From Kirkby Thore Parish Council ref 20032224

As noted in our previous representations to the various consultations on this project, Kirkby Thore Parish Council [KTPC] agrees that the A66 should be dual carriageway along its whole length. We accept that the route as it passes Kirkby Thore has been chosen as the Northern Route using the criteria stated by National Highways.

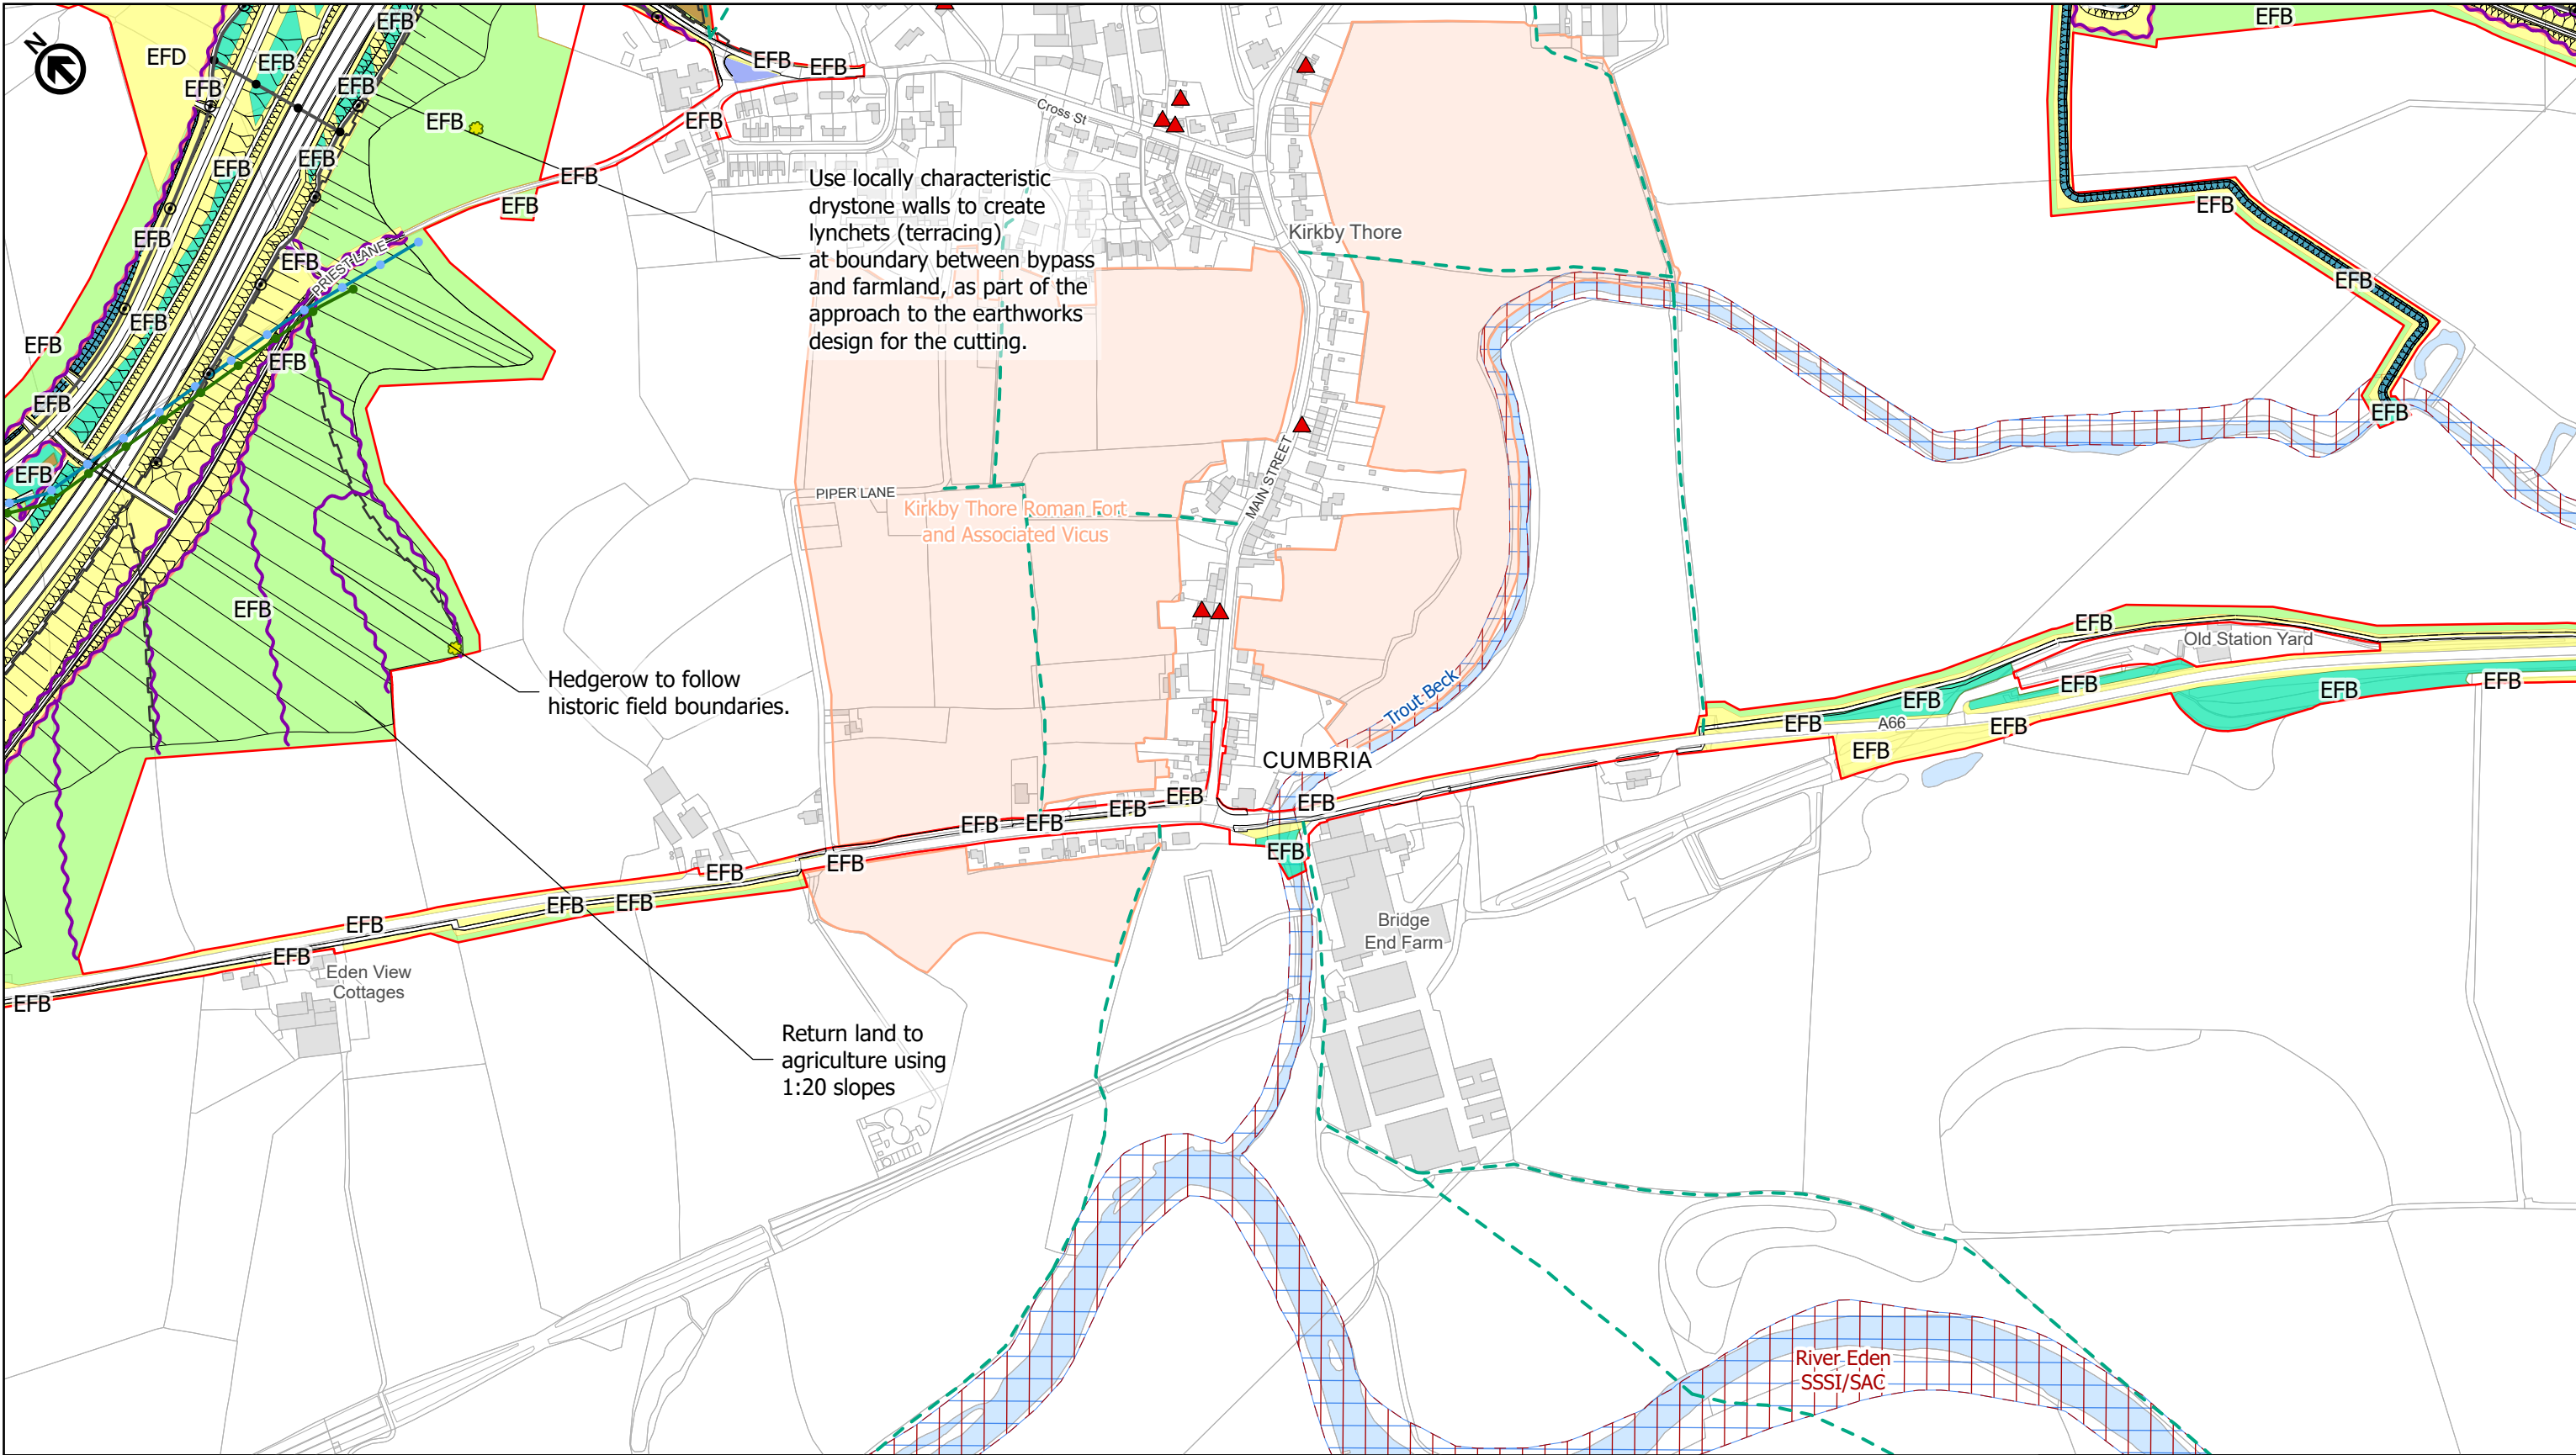
2) Environmental Mitigation Figure 2.8.3 Sheet 4 shows Sanderson's Croft immediately adjacent to the North Junction. The HGVs going to and from the Gypsum Works will curve round on the slip road up to grade and then over the overbridge. Hence the significant cut at this point of the road will not mitigate against much of the HGV noise and visual intrusion. The land between the junction and the Croft is shown as being returned to agricultural use but additional earth bunding or acoustic fencing masked by an area of woodland would significantly reduce the effects on the residents.

3) Figure 2.8.3 sheet 4 shows the primary school at a position along the A66 where it is not in cut but some earth bunding has been shown. Again the land between the school and its playing field is shown as being returned to agricultural use. And again acoustic fencing masked by an area of woodland or increased earth bunding would significantly reduce the noise and fumes effects on the pupils.

4) Figure 2.8.3 sheet 4 shows Dunfell View, which is 10m above the current ground level at the road position. The road has a certain amount of actual and false cut at this position but Dunfell View is still above this. Additional bunding might be oppressive to the road user in this case and thus woodland planting would give the most benefit to the residents against noise and headlight intrusion.

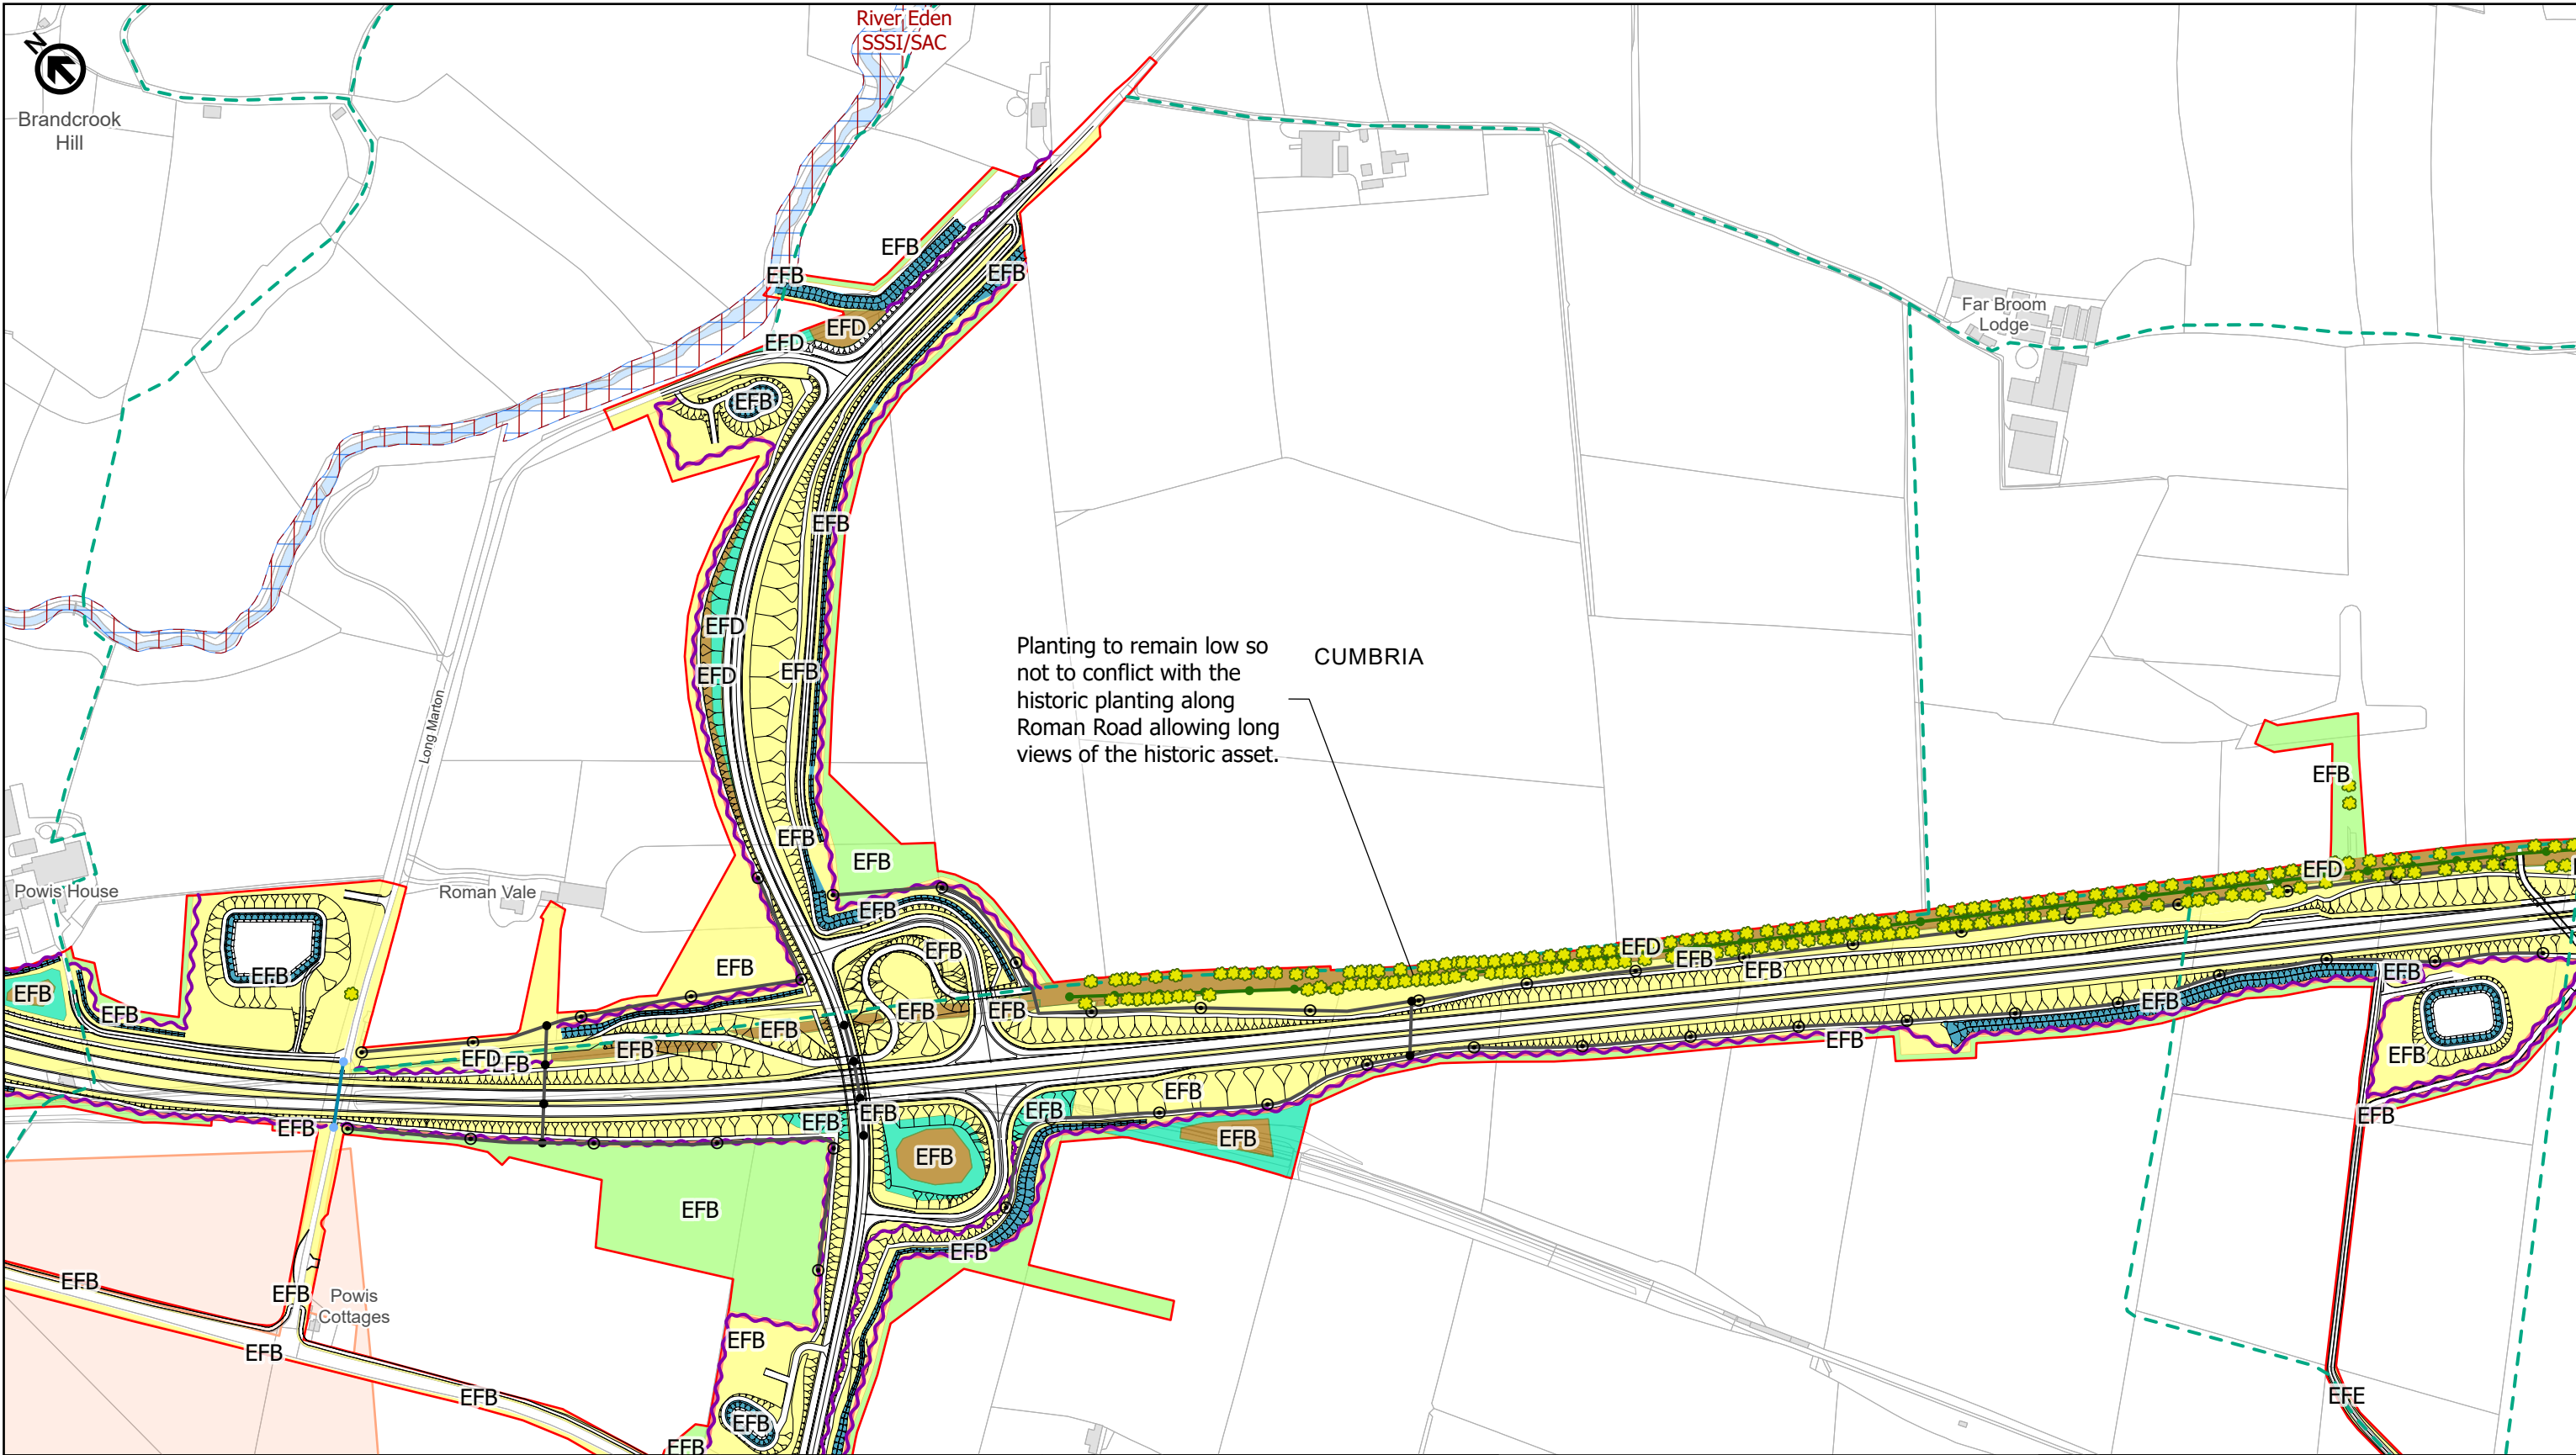
5) Map 1 shows Kirkby Thore Main St adjacent to the Trout Beck flood plain and Environmental Mitigation Figure 2.8.5 sheet 6 shows the eastern side of the flood plain and the length of road and viaduct unshielded from the residents on Main St. The existing A66 transmits a noticeable amount of noise to the eastern side of the village and the 70mph limit dual carriageway would produce 3 times the noise of the 40mph A66, as the noise energy is proportional to the square of

the speed. Acoustic fencing or baffles on the side of the Trout Beck viaduct could reduce the adverse effects on the residents. The proposed viaduct will also loom large in the landscape and impact on the villagers view to Appleby along the low lying plain. This is a loss to the residents that cannot be amended but highlights the importance of mitigating the nuisances of noise and headlight intrusion.

7) The environmental mitigation figures show two areas for lapwings, one of which is the area currently known as the Mire [noted on sheet 6] and is a wetland. Proposed retention of this area as a wetland is appreciated. However, we believe that both the areas shown may be too close to a busy road for lapwings to use. Has any consideration been given to additional areas further from the A66? Deer and hares also roam across this area to the north of the village and no specific consideration has been noted for them. Several buzzards use the area as hunting territory. The use of road verges for wildlife corridors is important when roads cut across territories thus fencing design is important to protect the vehicles from the larger wildlife while permitting movement. The Environmental Mitigation figures do not appear to show this level of detail but we note the importance of wildlife corridors and suitable fencing.

8) Figure 2.8.3 sheet 6 appears to show drainage ditches from the SuDS ponds directly into the Trout Beck, which is part of the Eden SAC. Can it be explained why this is acceptable.
